Application Ref:	2025/0603			 Ribble Valley Borough Council www.ribblevalley.gov.uk
Date Inspected:	N/A	Site Notice:	N/A	
Officer:	SK			
DELEGATED ITEM FILE REPORT:				NMA APPROVAL

Development Description:	Non-material amendment to application 3/2024/0990 involving change in window/door positions and change of materials on entrance elevation (stone instead of render).
Site Address/Location:	Barrowbridge House Club Street Barrow BB7 9AY

| Drawing Title<br>Plot 2 Proposed Plans and Elevations                                                      |                  |              |

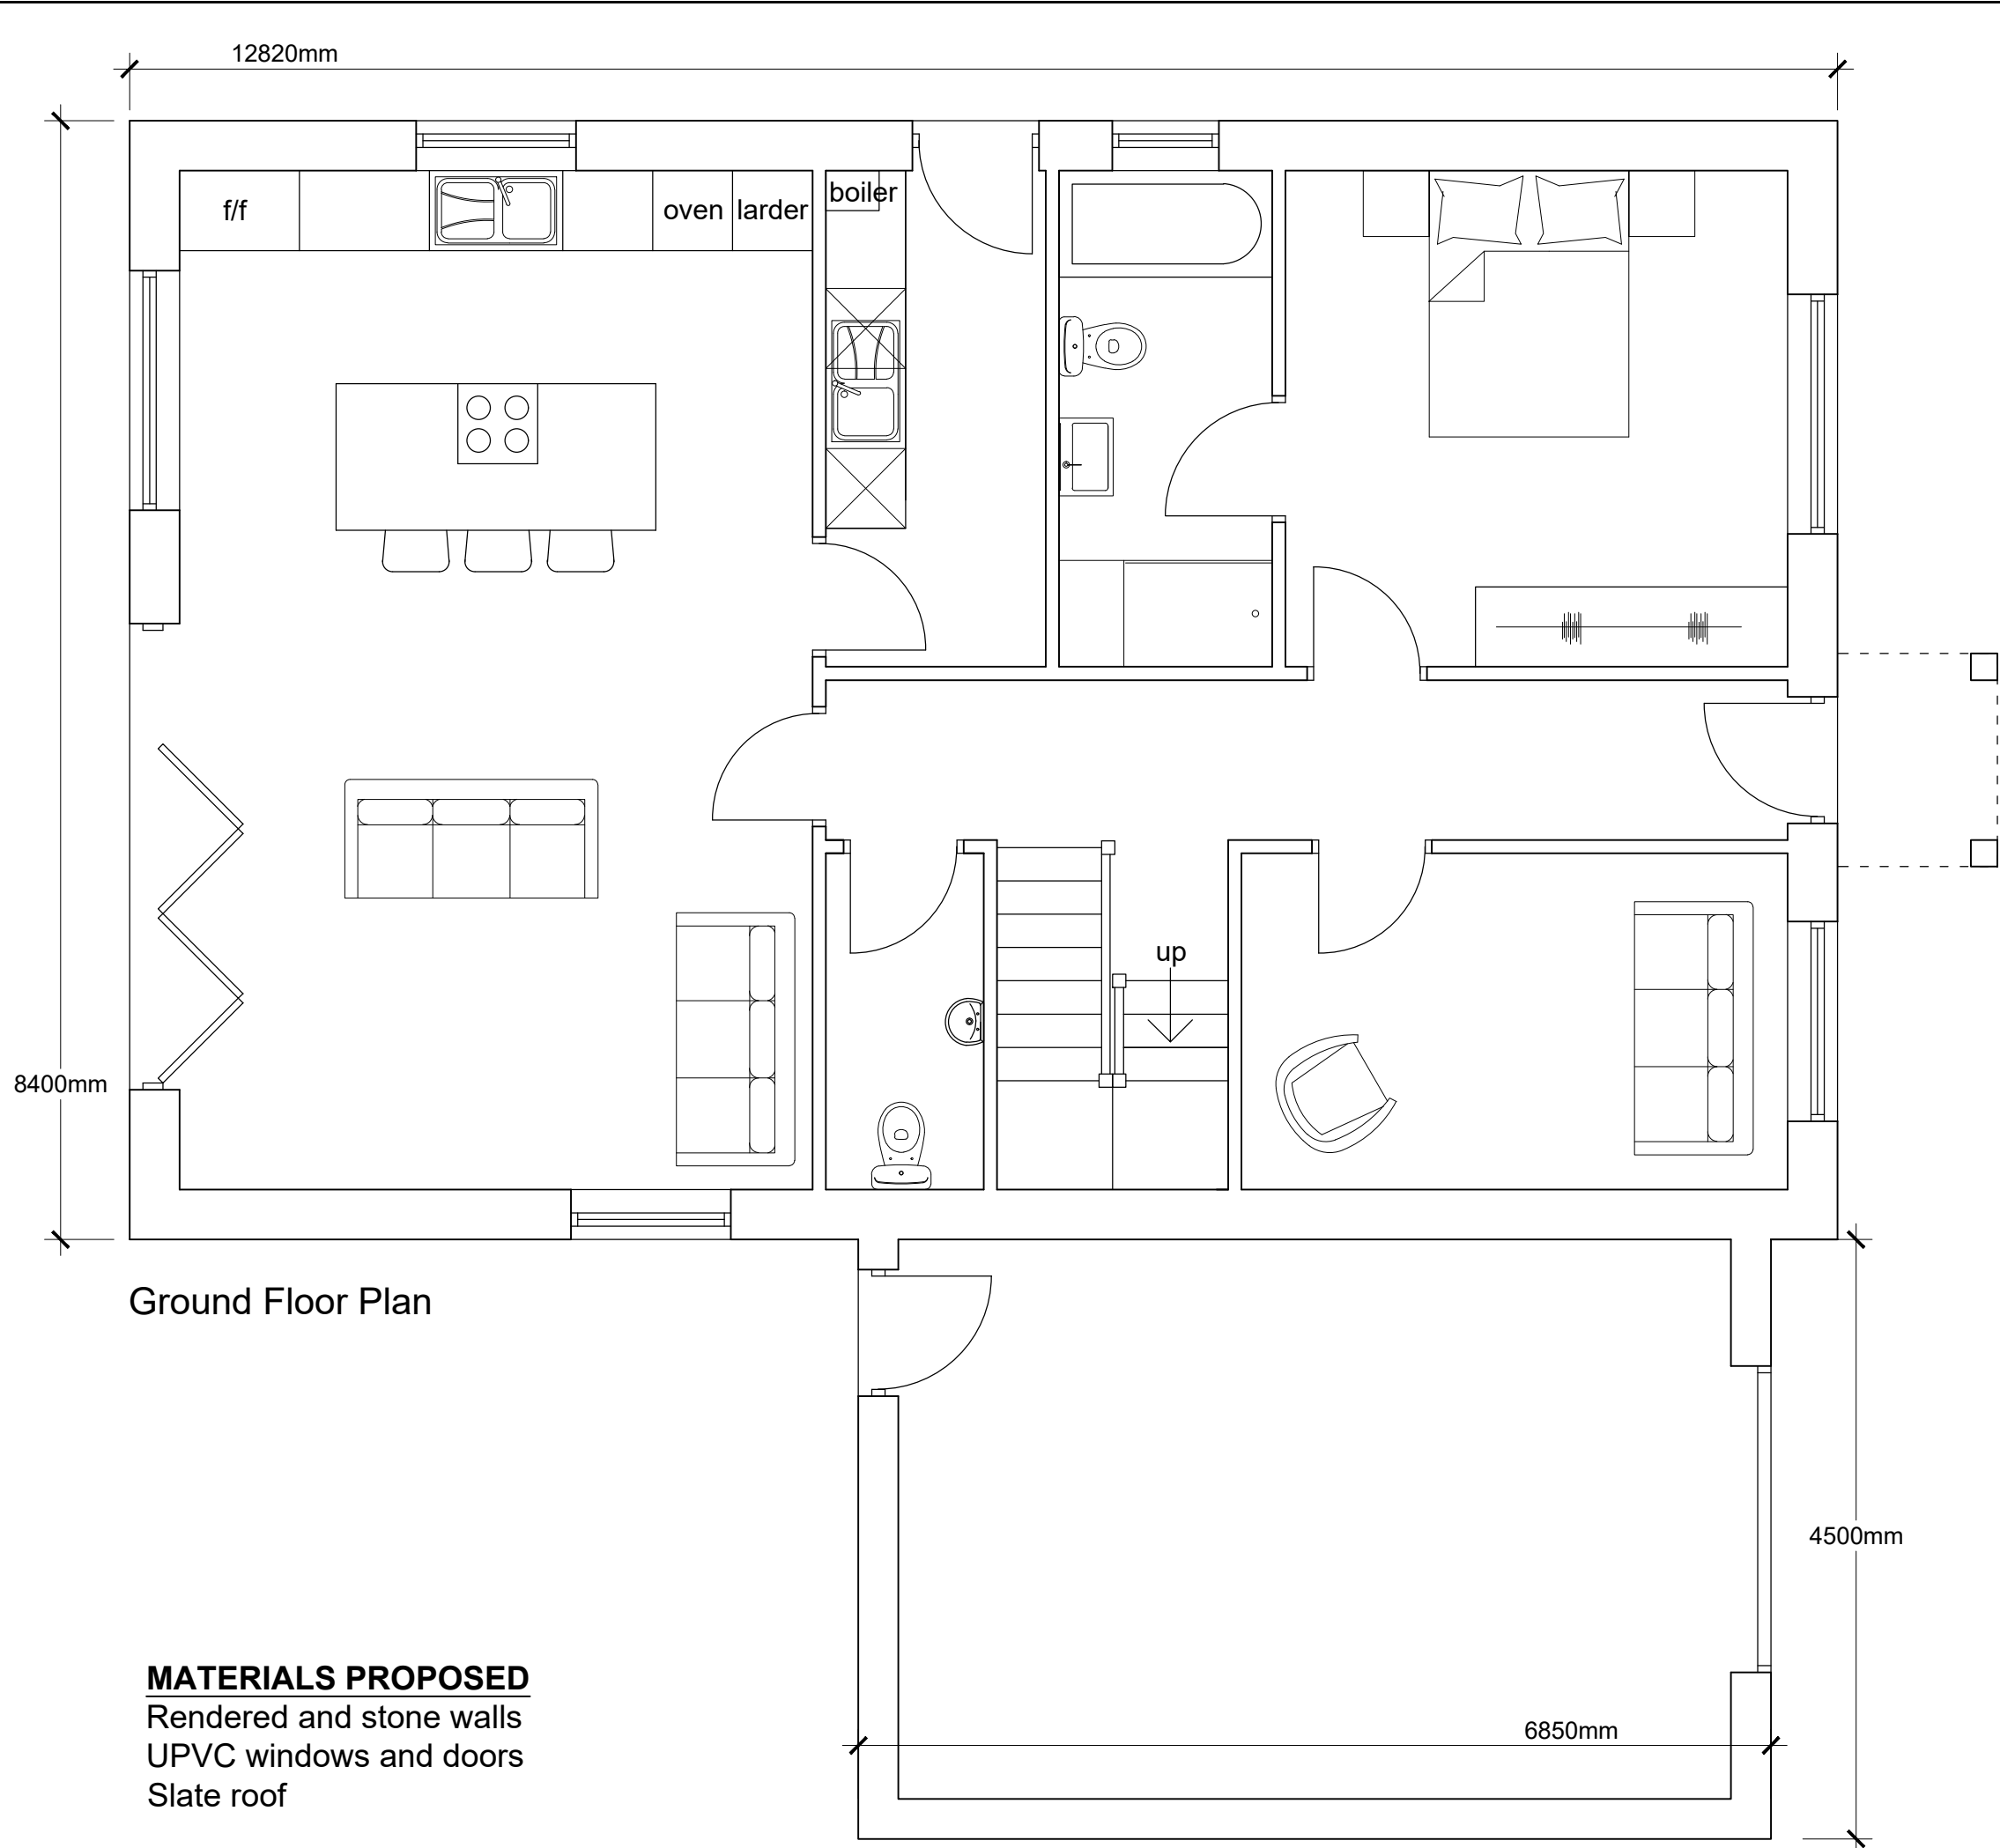
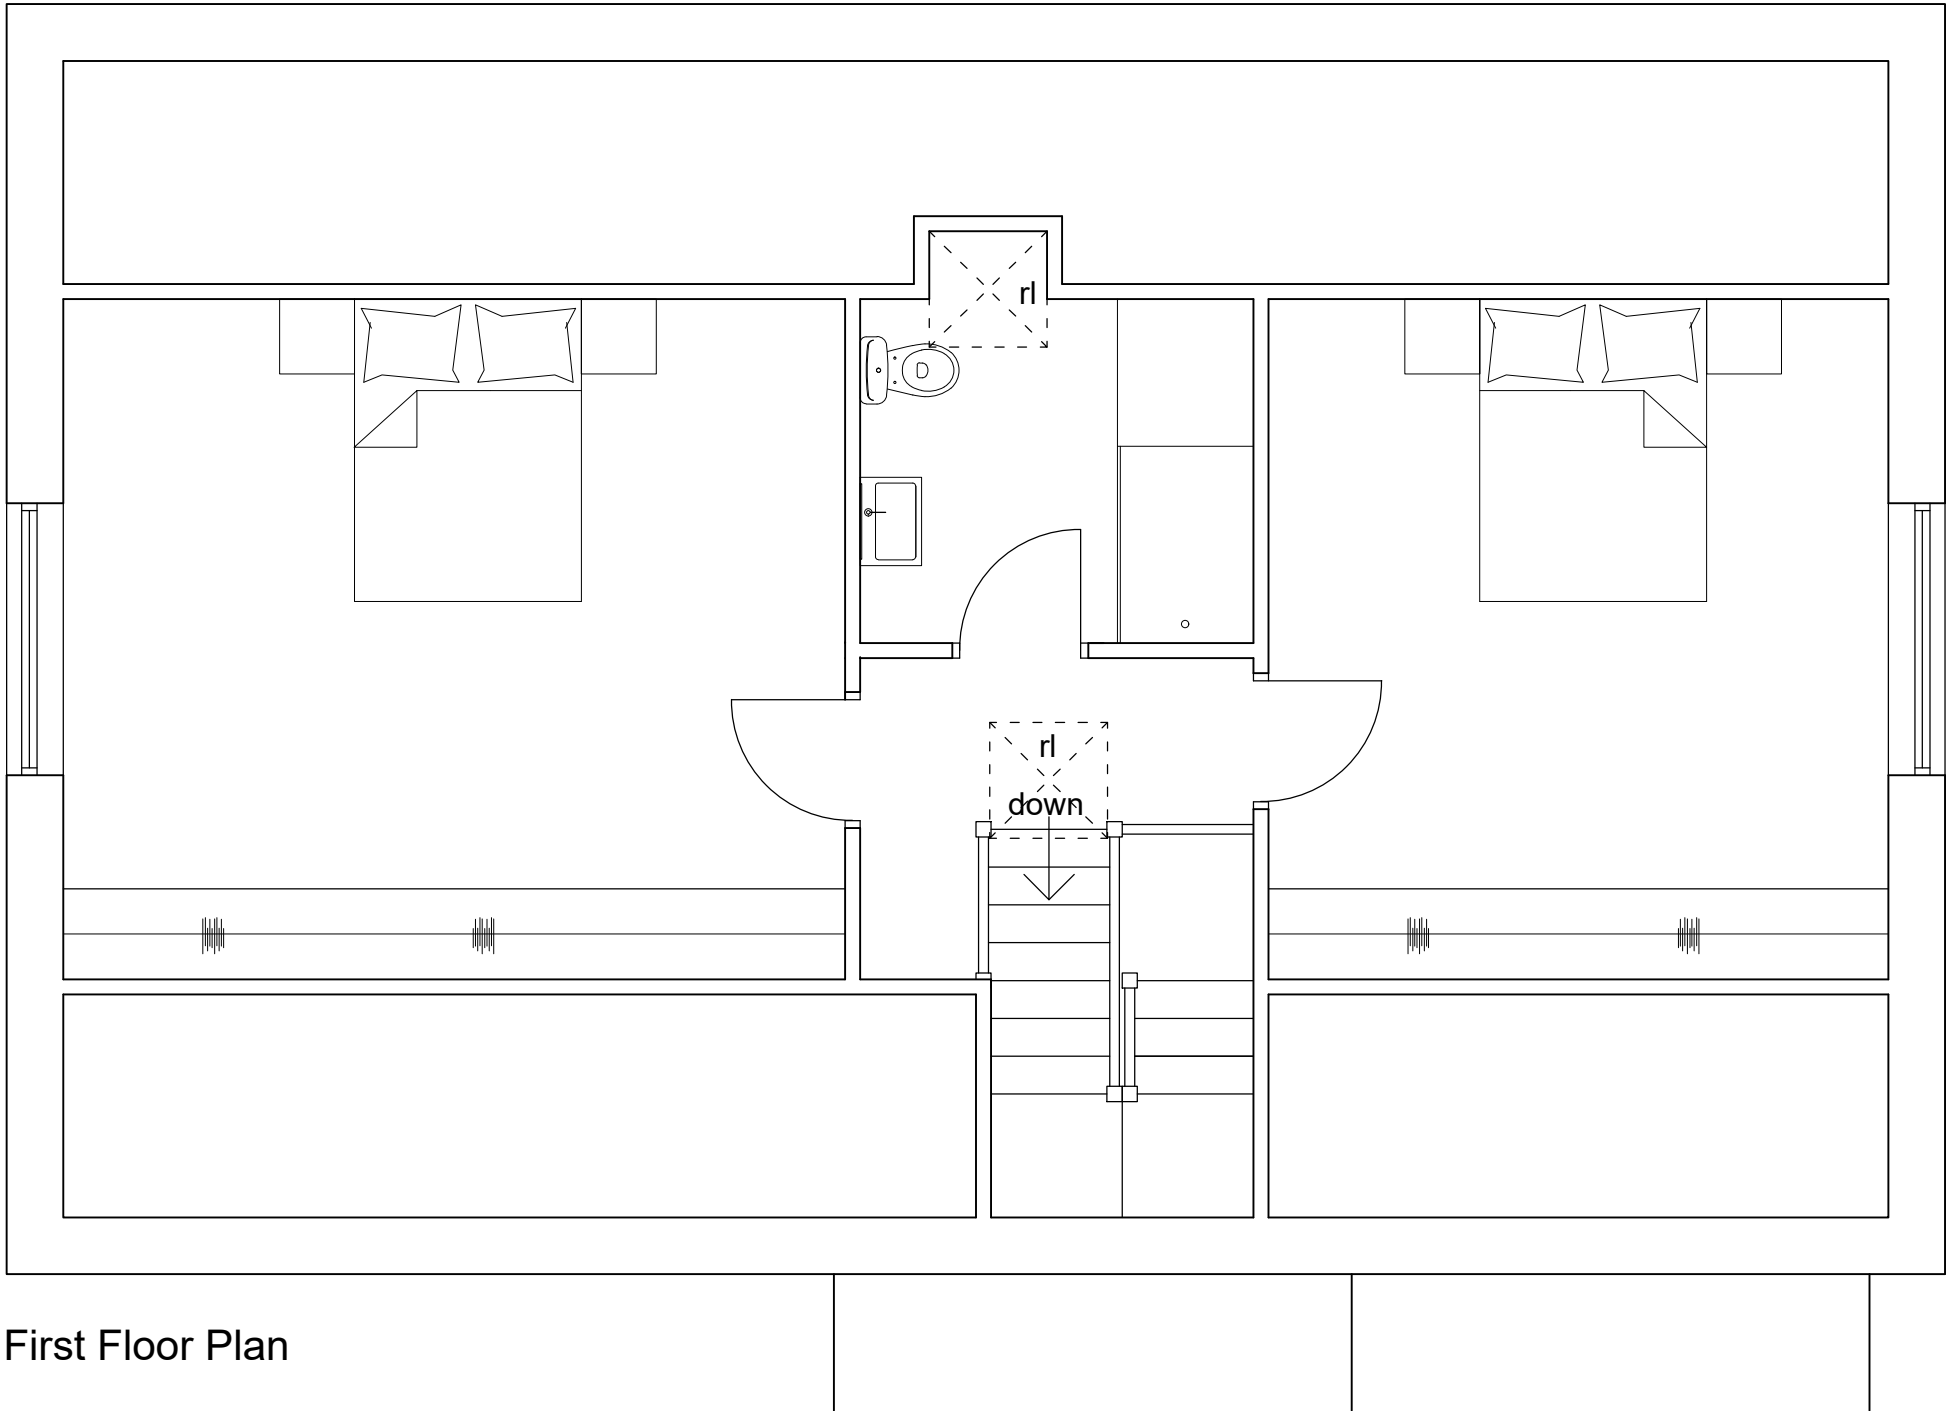
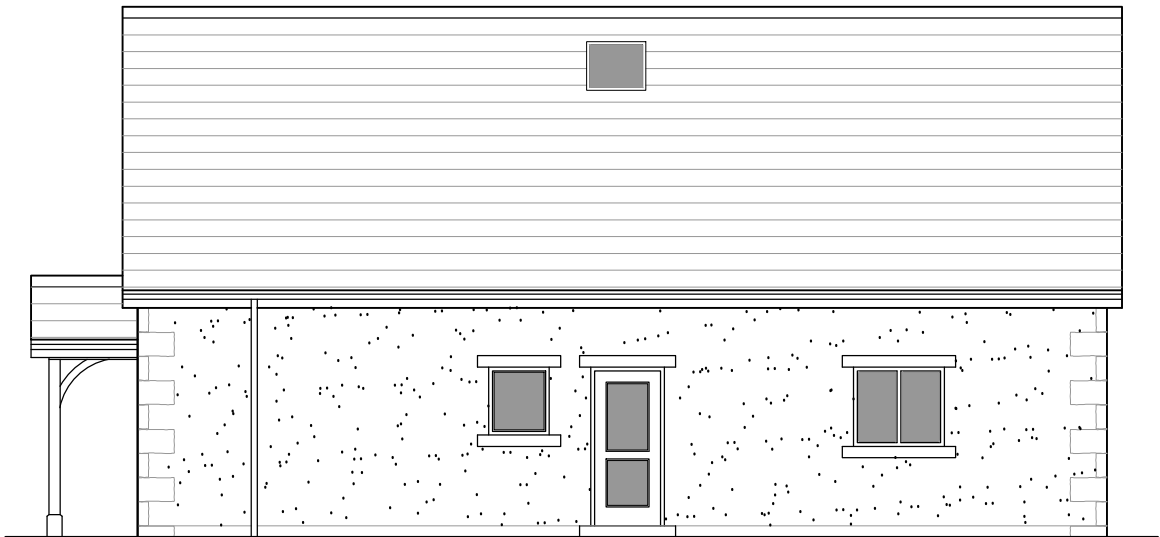
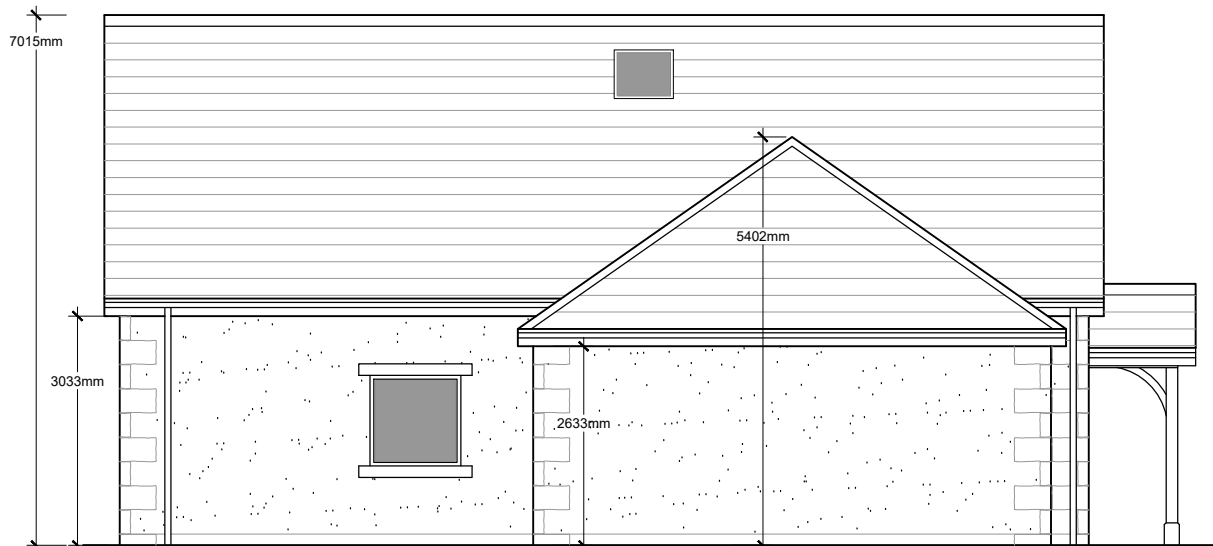
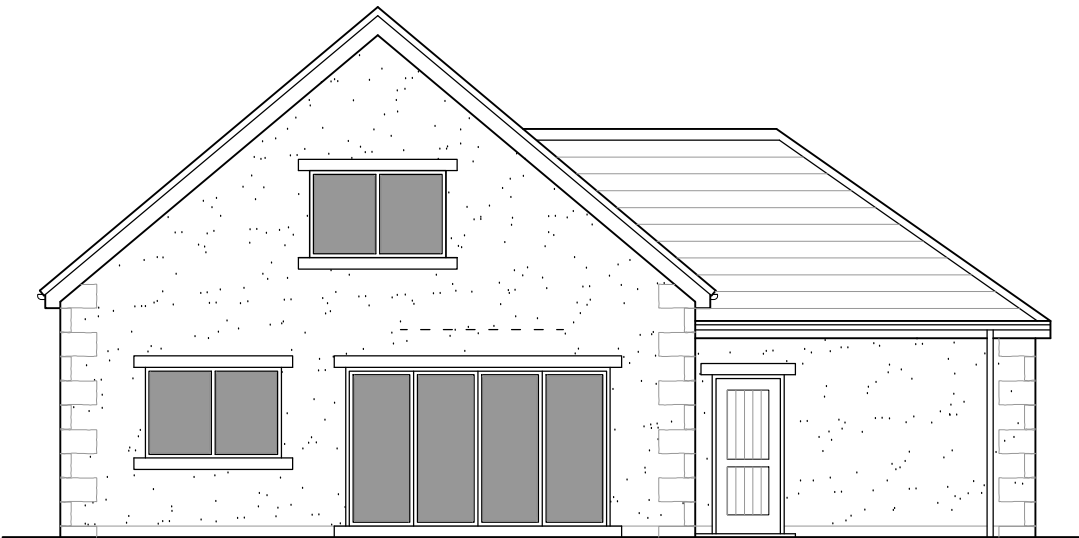
Plot 02:

North-East Elevation:

- Amendment to window locations and introduction of window to serve newly located internal staircase.
- Head and sill detailing added

North-West Elevation:

- Head and sill detailing added

South-East Elevation:

- Introduction of new window at ground floor
- Use of stone on elevation in-lieu of render
- Head and sill detailing added

South-West Elevation:

- Head and sill detailing added

Internal Floorplan:

- Revised location of internal staircase
- Snug introduced at ground floor

- First Floor layout reconfigured
